SEAS WRITTEN REPRESENTATION OF THEIR
ISH2 ORAL REPRESENTATION on
NOISE and VIBRATION

SEA LINK: EN020026

Sea Link DCO EN020026 - ISH2 29 January 2026

Noise evidence of Rupert Thornely-Taylor, Fellow of the Institute of Acoustics on behalf of Suffolk Energy Action Solutions (SEAS)

- Figure 1 Indicative Sound Propagation Model Outputs - Specific Noise Level; and
- Figure 2 Indicative Sound Propagation Model Outputs - Night-time Noise Ambient Noise Level Change.

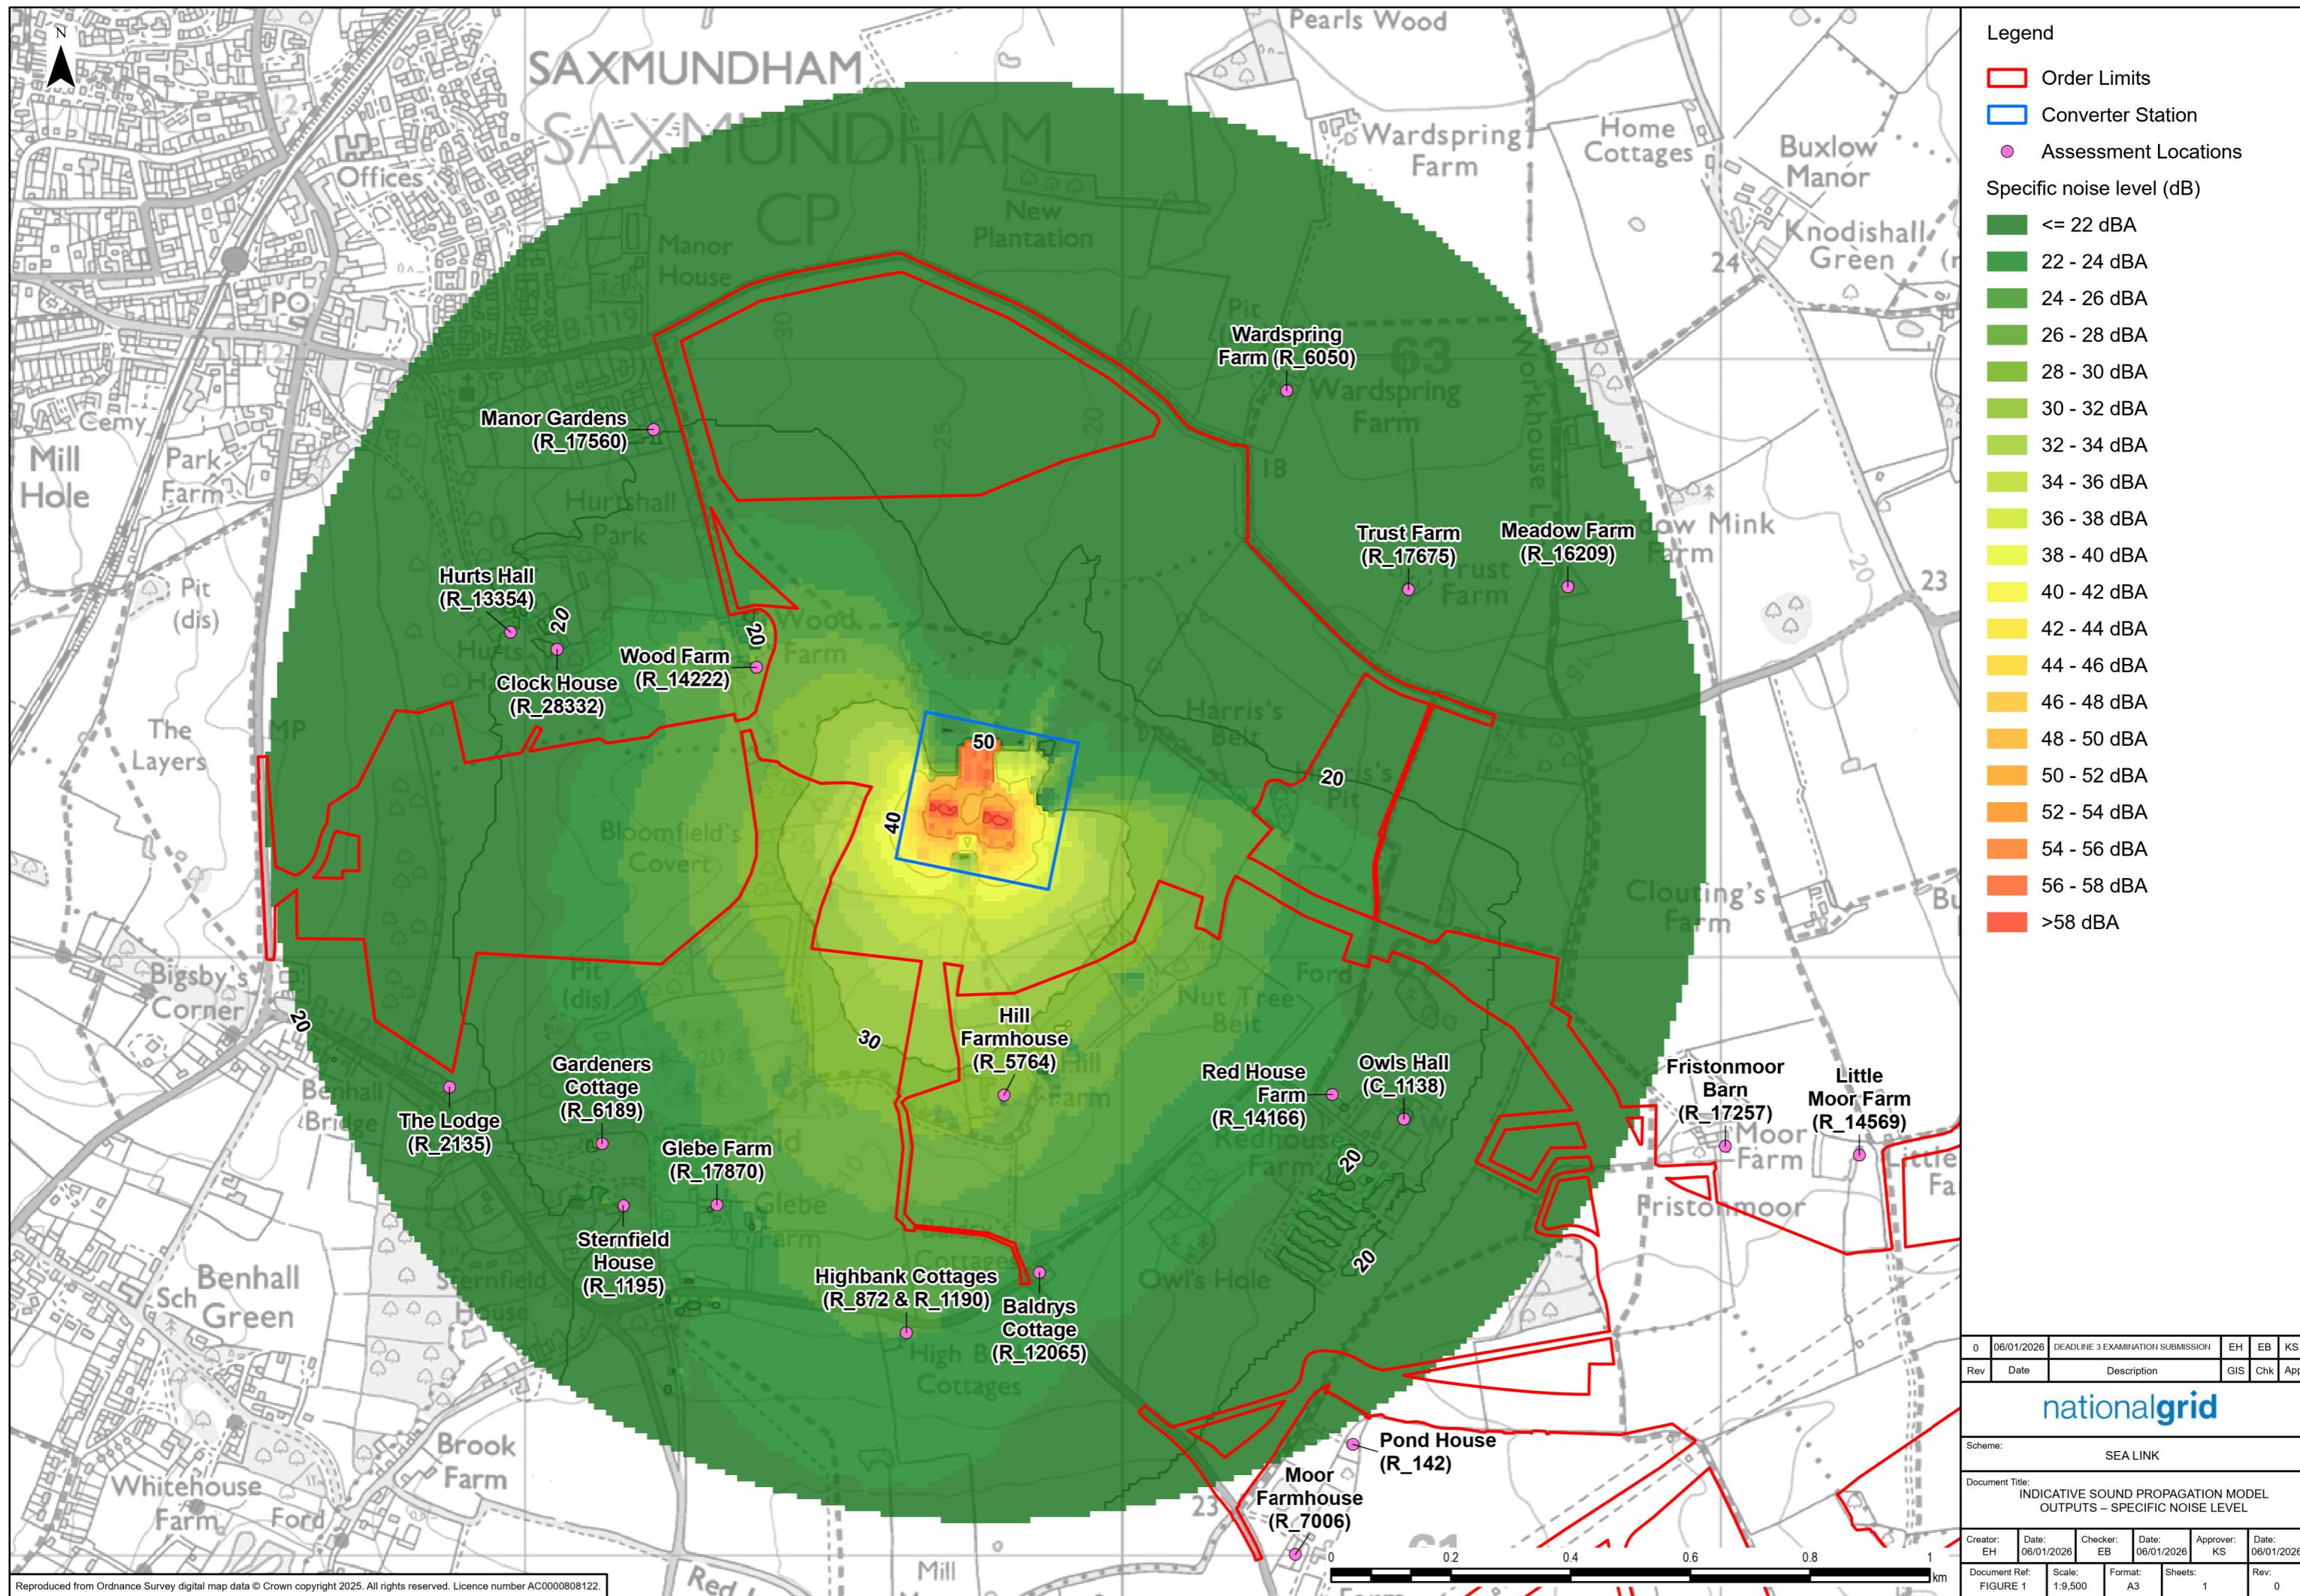
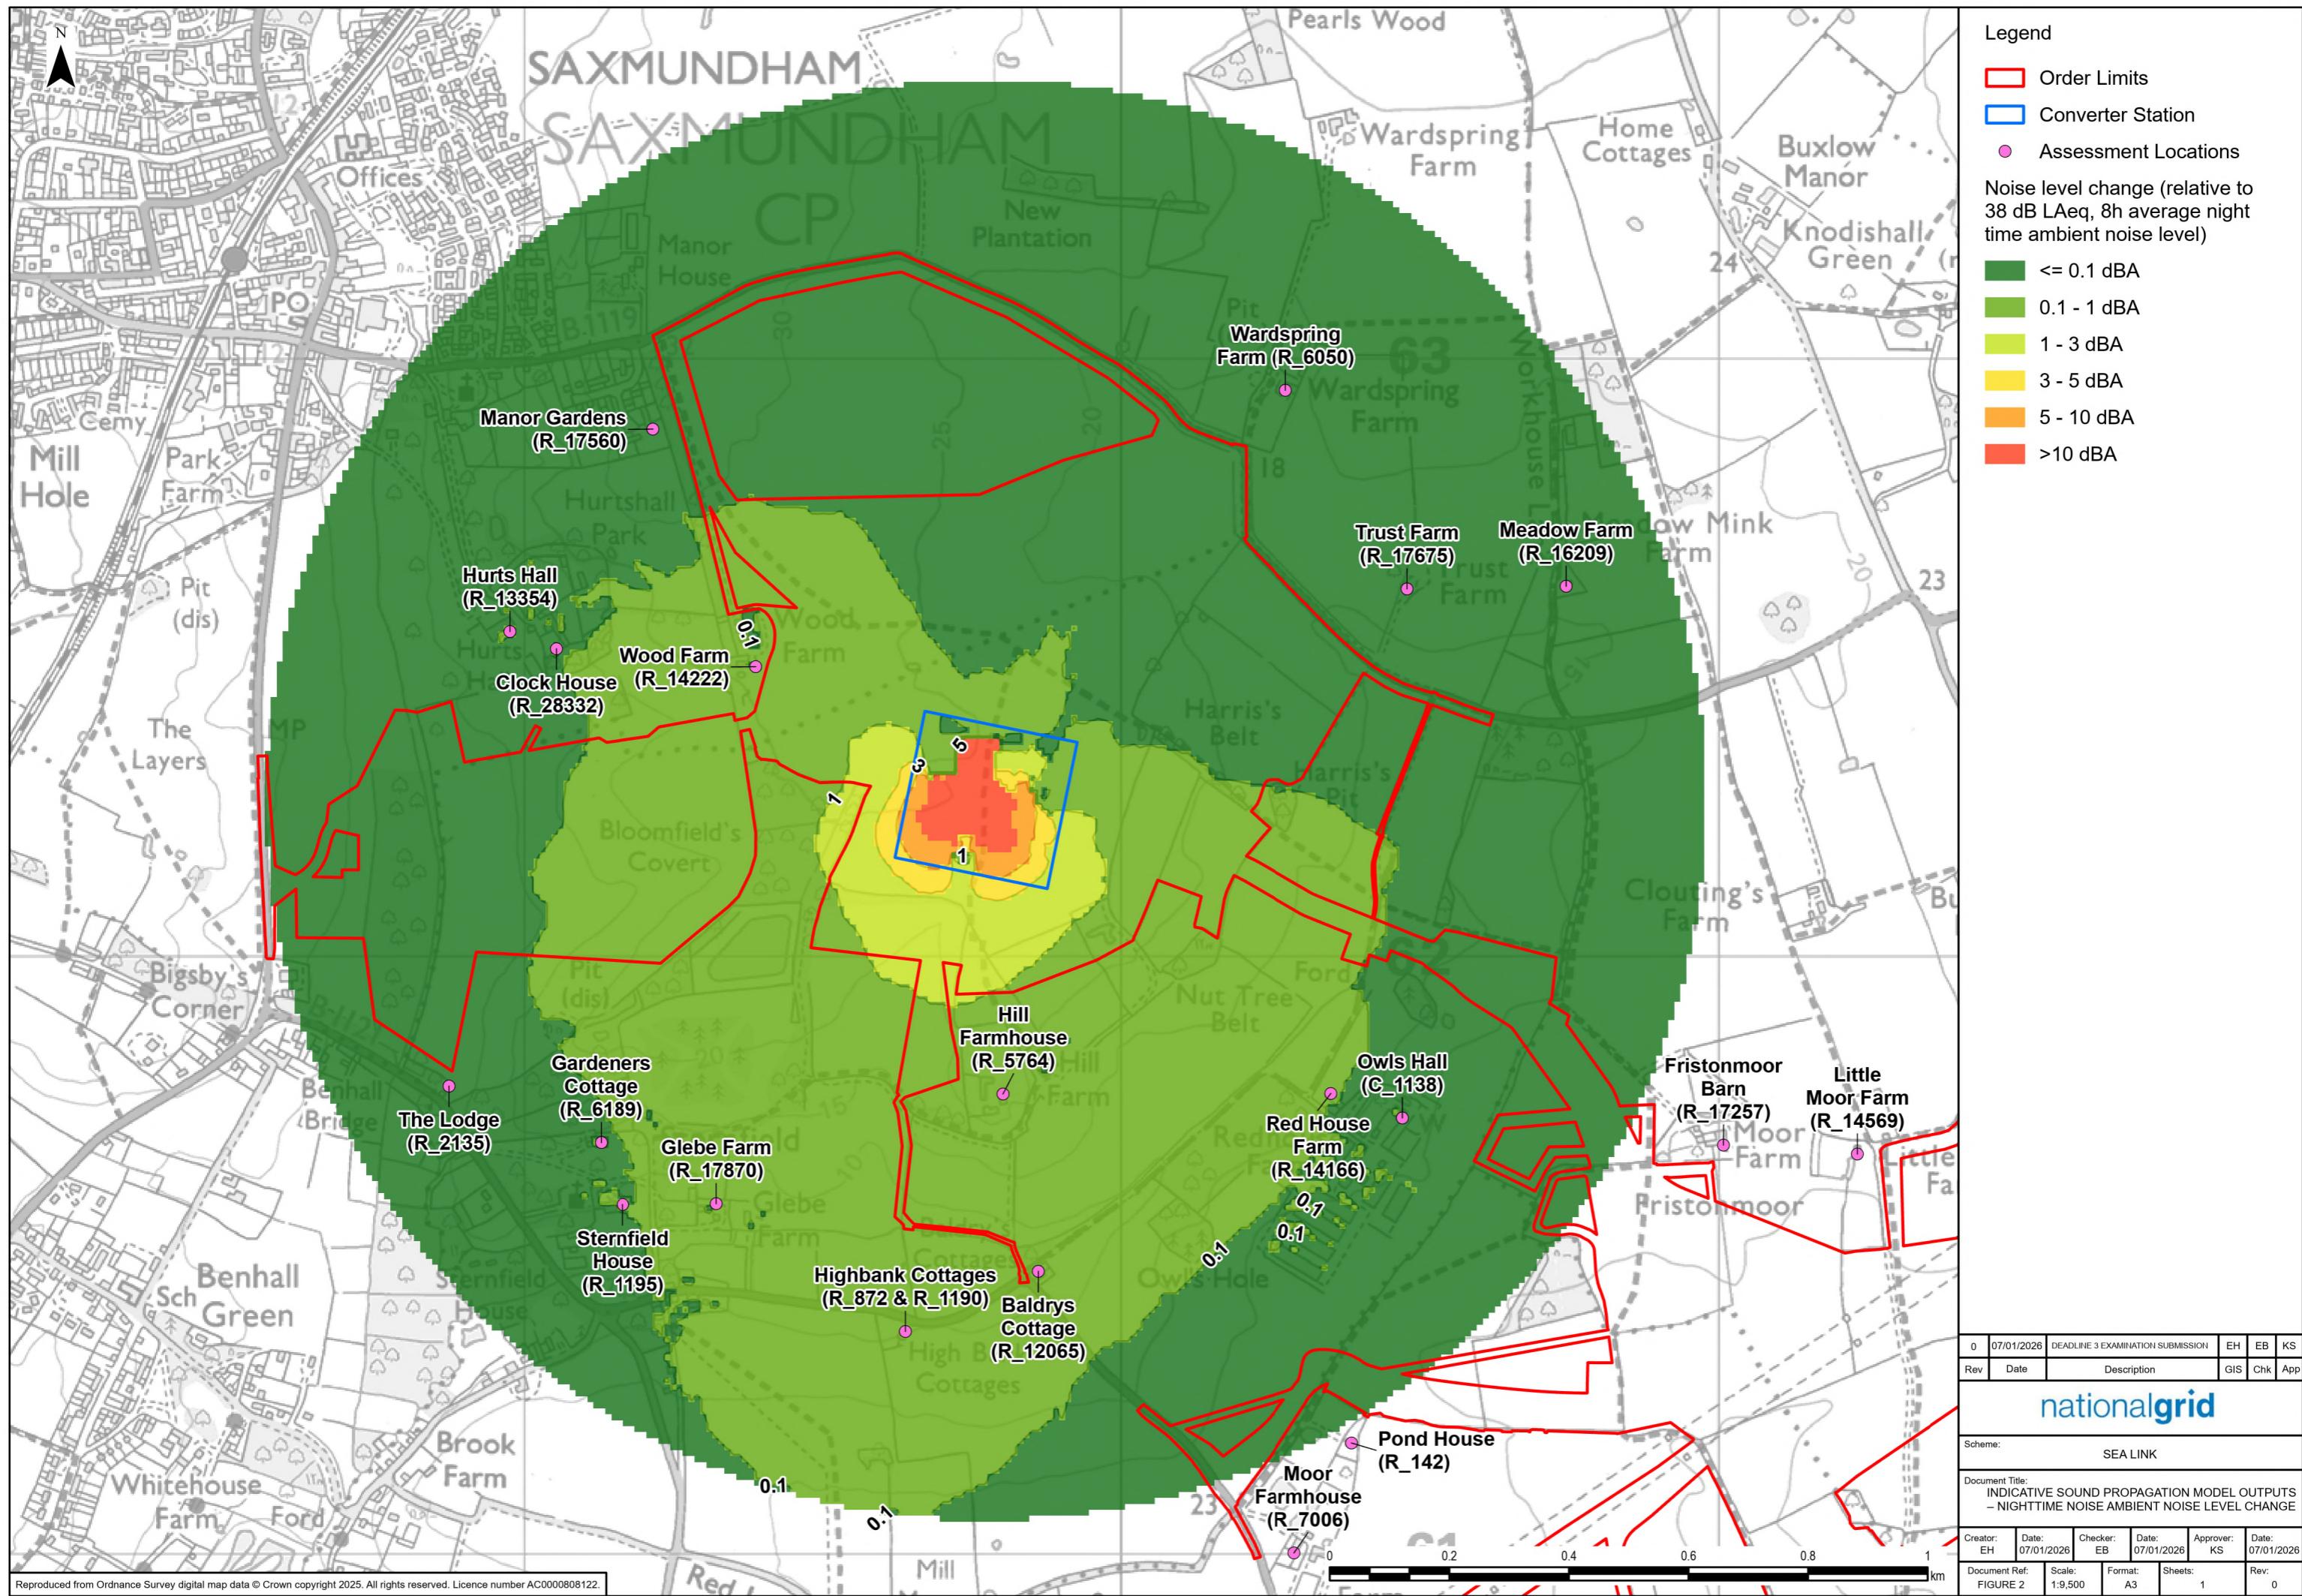
No noise or vibration prediction has been made by the applicant for the operation of this development. The ES (Appendix 2.9.D I.1.1.) states in its introduction that it “does not provide a definitive indication of noise impacts from the proposed Saxmundham Converter Station” and instead presents “an assessment of noise from a ‘generic’ converter station with standard noise mitigation measures applied”. Noise contours have been provided in “Document 9.82: Operational Noise Contour Plan for Saxmundham Converter Station” REP3-075, but these are labelled “indicative” and are therefore do not present the results of a prediction exercise specific to this proposal taking account of the actual noise sources and their engineering specifications which are to be installed if consent is granted.

The Secretary of State cannot be satisfied that those aims will be met, firstly because a prediction specific to this application has not been made in accordance with 5.12.12 of EN-1, and secondly the draft DCO contains no requirement specifying numerical limits on operational noise or in any other way giving effect to 2.7.98 of EN-3. The applicant is relying on future unspecified design effort to avoid significant effects and this could only be acceptable if it is demonstrated that the mitigation measures to be applied are feasible from an engineering point of view, and that achievement of the outcome relied on can be enforced through explicit Requirements contained within the DCO. The particular characteristics of the major potential noise sources involved in a development of this kind, including the fact that electrical transformers emit tonal noise which can result in both higher sound levels at receptors than general approaches to noise assessment predict, and cause more significant noise impacts than noise sources without these characteristics.

My expert view is, firstly, that the Examining Authority should, prior to reporting to the Secretary of State, require the applicants to carry out a full set of operational and construction noise predictions, taking into account the actual equipment, machinery and plant that it is intended to install, and applying site-specific mitigation measures based on the performance of actual noise reduction measures and not generic assumptions. The predictions should of course take fully into account corresponding predictions from other developments in the area which are capable of contributing to a cumulative effects. Secondly, the DCO should be amended to include requirements stating numerical noise limits for both operational and construction noise in the manner of other comparable Orders.
